CITY OF ALBUQUERQUE

February 9, 2017

**Re: Sonic Drive-In
6310 4th St NW
Request for Permanent C.O. - Accepted
Engineer's Stamp Date 7-10-16 (E15D017)
Certification date: 1-20-17**

SITE PLAN 1" = 20'

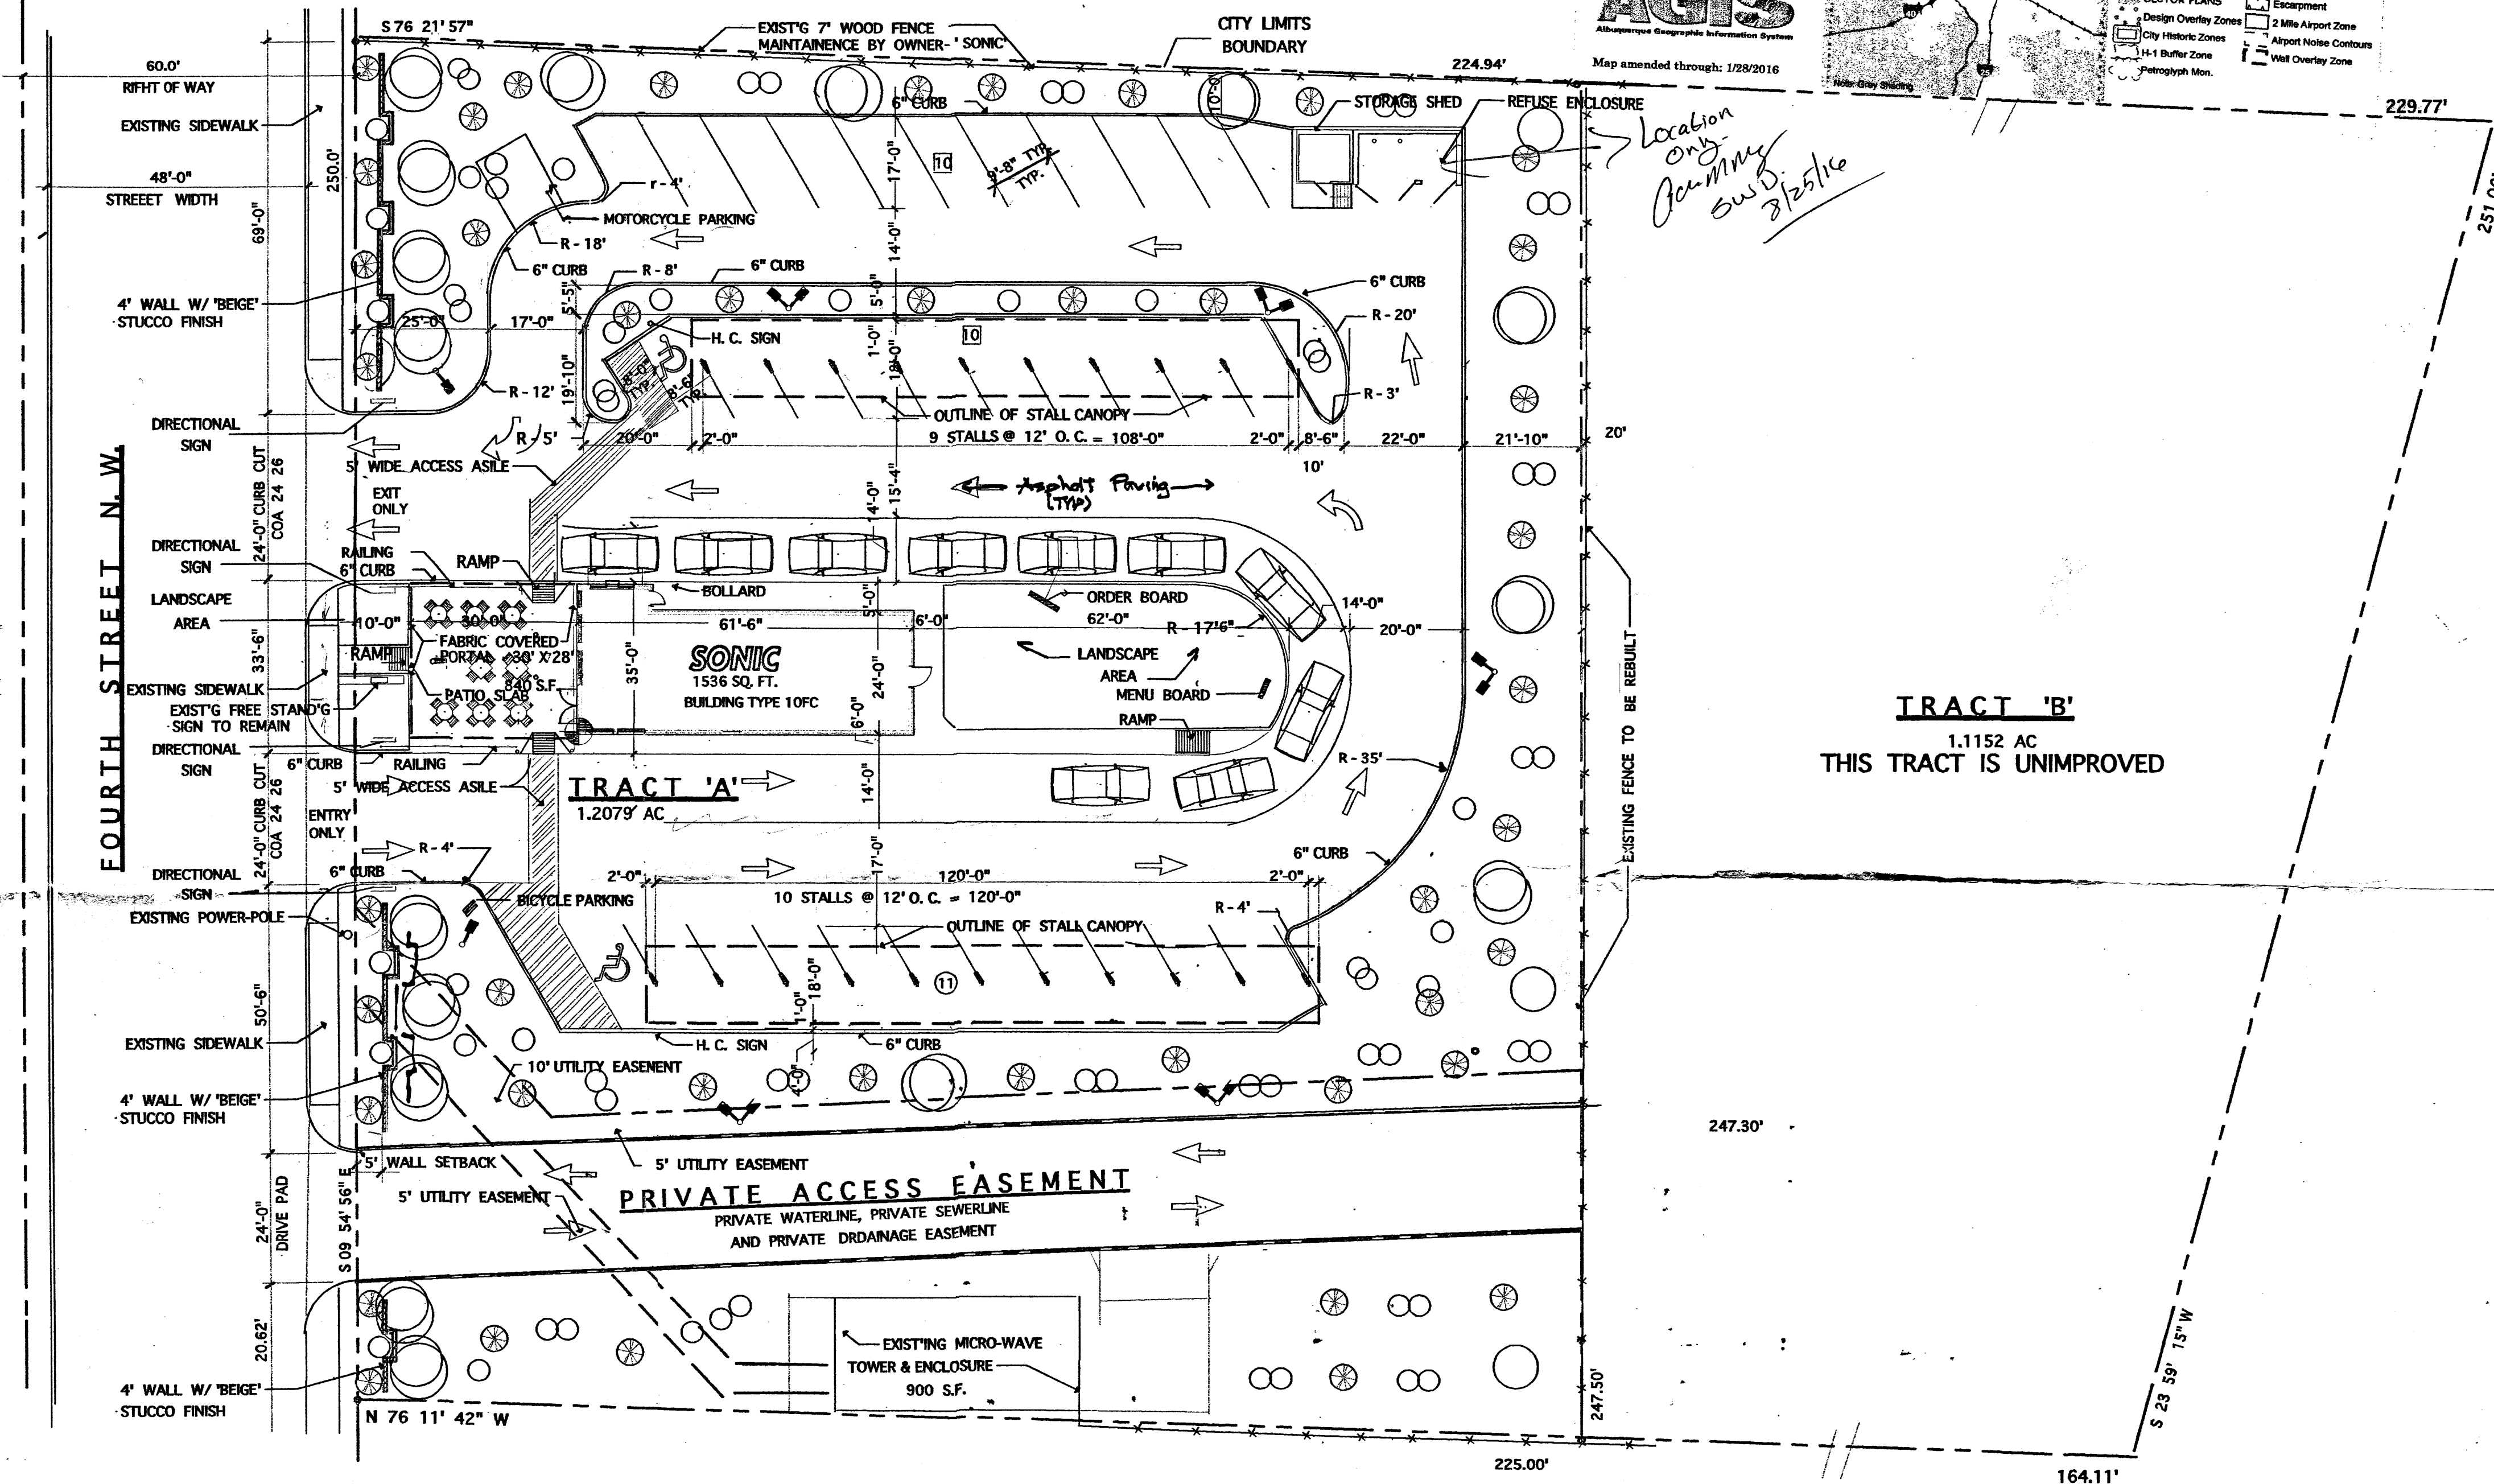
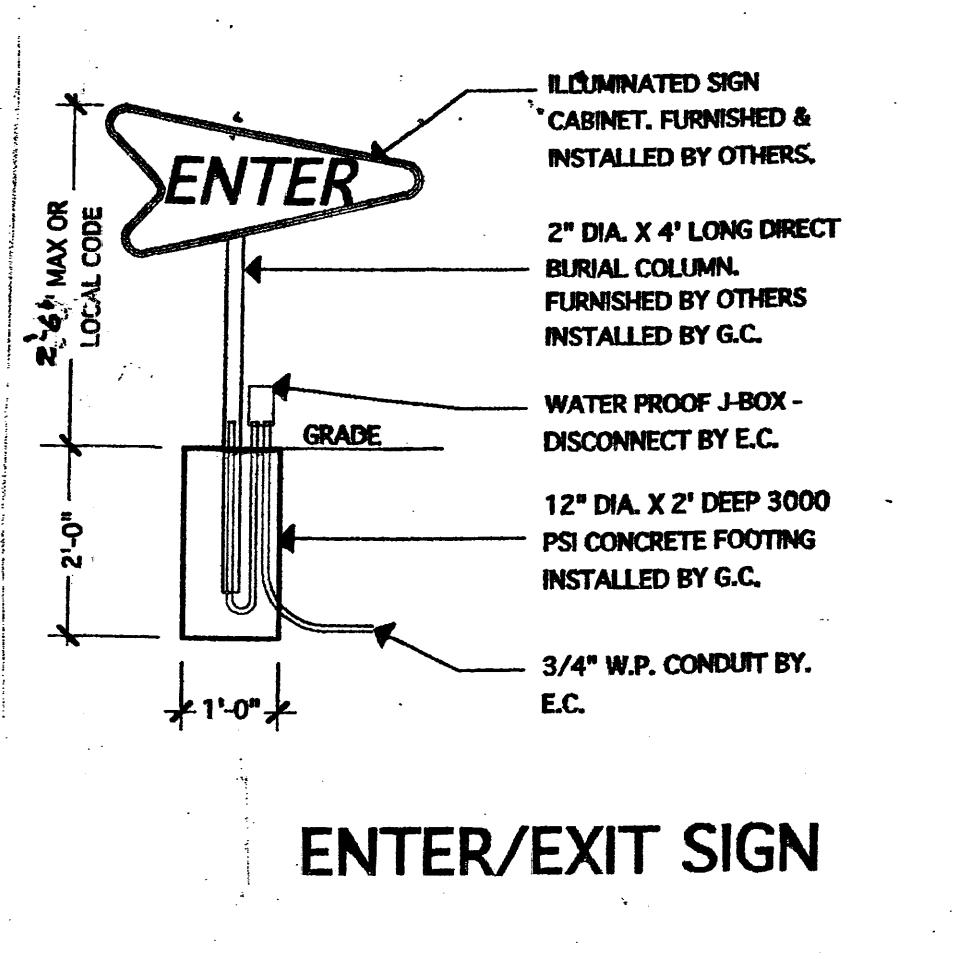
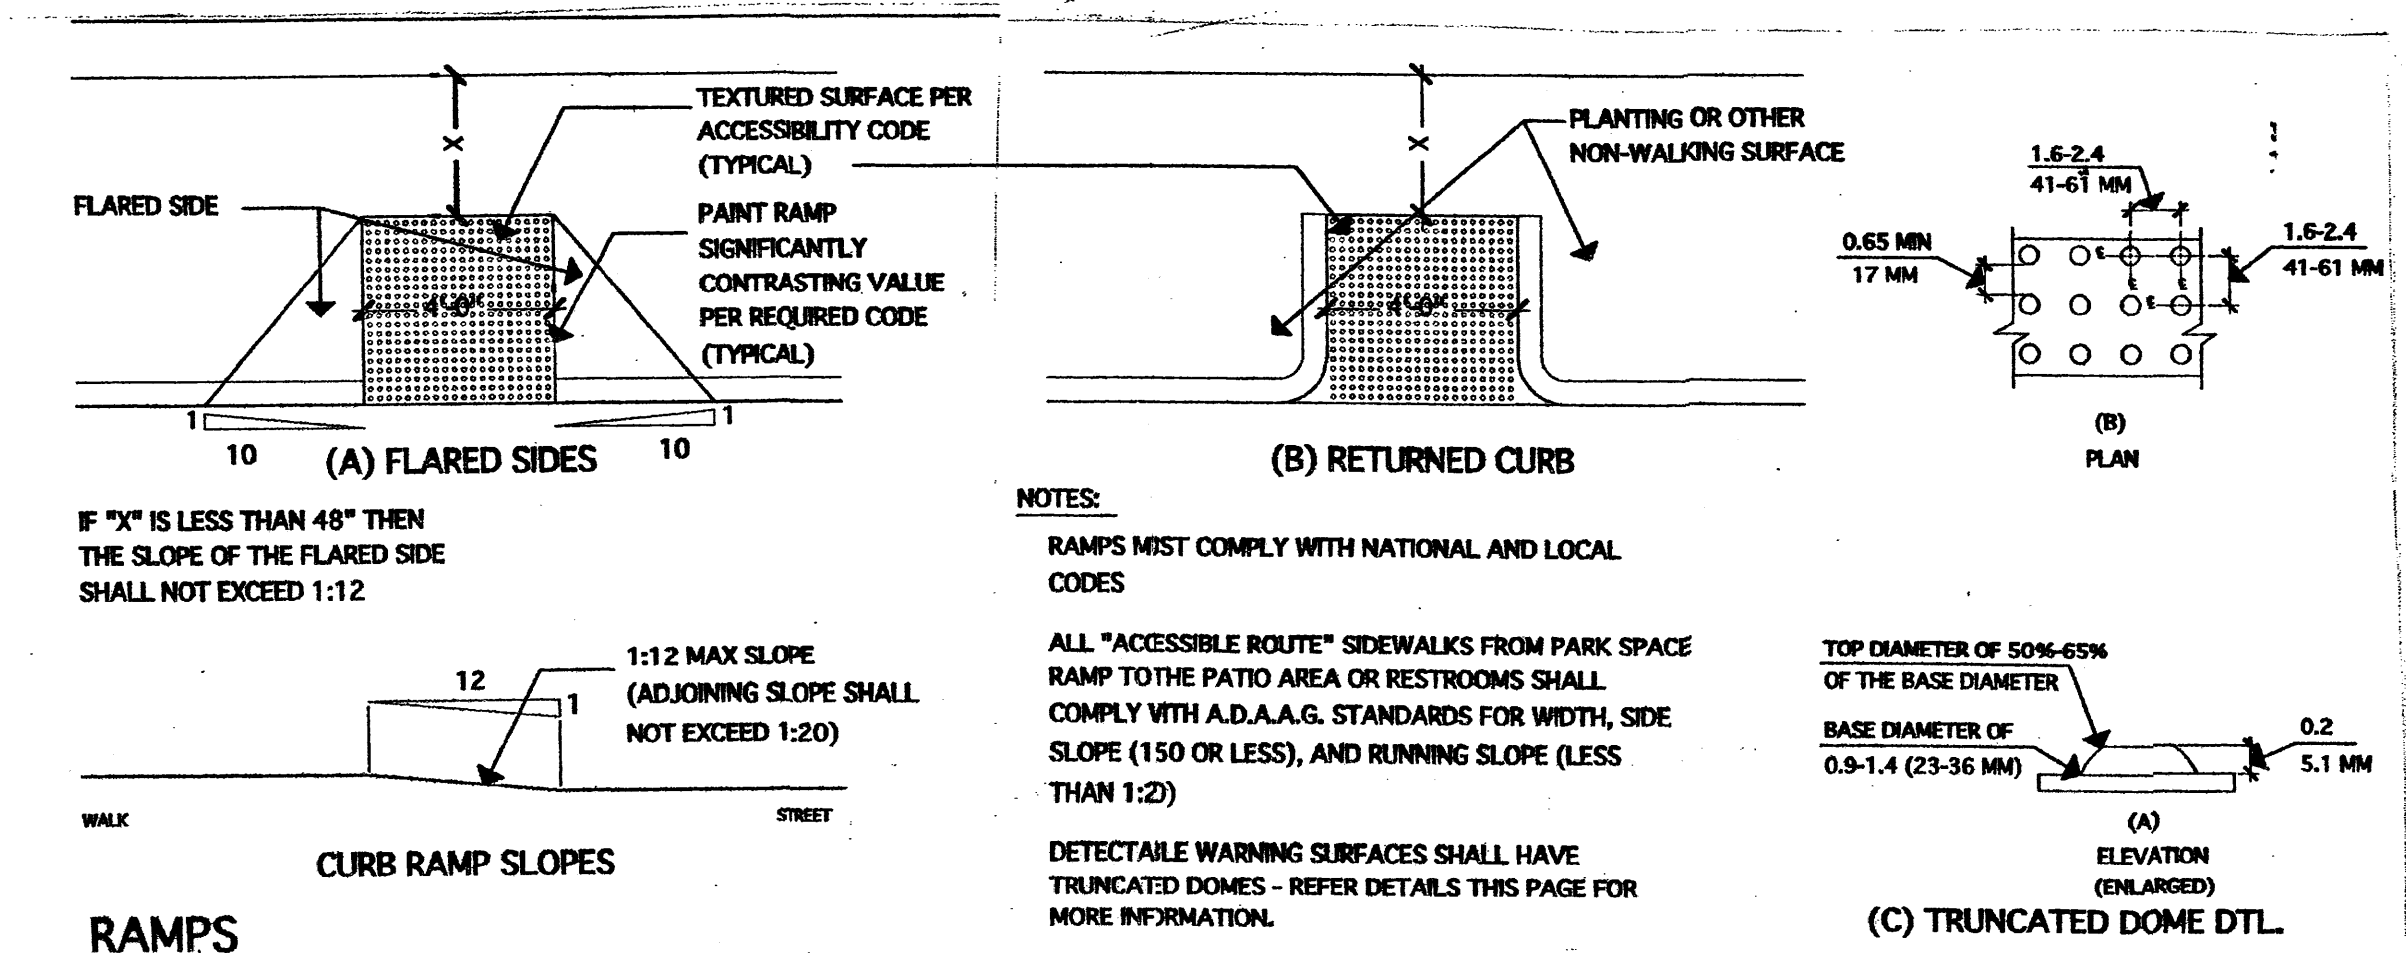
- ✓ 1. Please show a vicinity map showing the location of the development in relation to streets and well known landmarks.
- ✓ 2. The traffic circulation layout must be stamped, signed, and dated by an engineer or architect licensed in the state of New Mexico.

- ✓ 3. Identify the right of way width, medians, curb cuts, and street widths on 4th St.
- ✓ 4. Clearly show existing sidewalk and handicapped ramps on site and within the public right-of-way. Provide detail and standard drawing number for new construction.

- ✓ 5. Please list the width for all proposed parking spaces at the north end of the property.
- ✓ 6. The handicap accessible spaces must be a minimum of 8.5 ft. in width.

- ✓ 7. The handicap accessible spaces must include an 8 ft. wide van access aisle; all other aisles should be 5 ft. in width.
- ✓ 8. The ADA accessible parking sign must have the required language per 66-7-352.4C NMSA 1978 **"Violators Are Subject to a Fine and/or Towing."** Please call out detail and location of HC signs.

- ✓ 9. The ADA access aisles shall have the words **"NO PARKING"** in capital letters, each of which shall be at least one foot high and at least two inches wide, placed at the rear of the parking space so as to be close to where an adjacent vehicle's rear tire would be placed. (66-1-4.1.B NMSA 1978)

- ✓ 10. Provide dimension of motorcycle parking and signage.
- ✓ 11. Motorcycle parking cannot be placed backing into ADA accessible aisle
- ✓ 12. Provide the required bicycle parking for the facility.

- ✓ 13. The minimum lane widths for drive-through facilities are 12' with a 25' minimum radius (inside edge) for all turns. A 15' radius can be used with an increase in lane width to 14'.

- ✓ 14. List radii for all curves shown; for passenger vehicles, the minimum end island radius is 15 ft. Landscape island radius for delivery trucks, fire trucks, etc. is 25 ft. or larger.
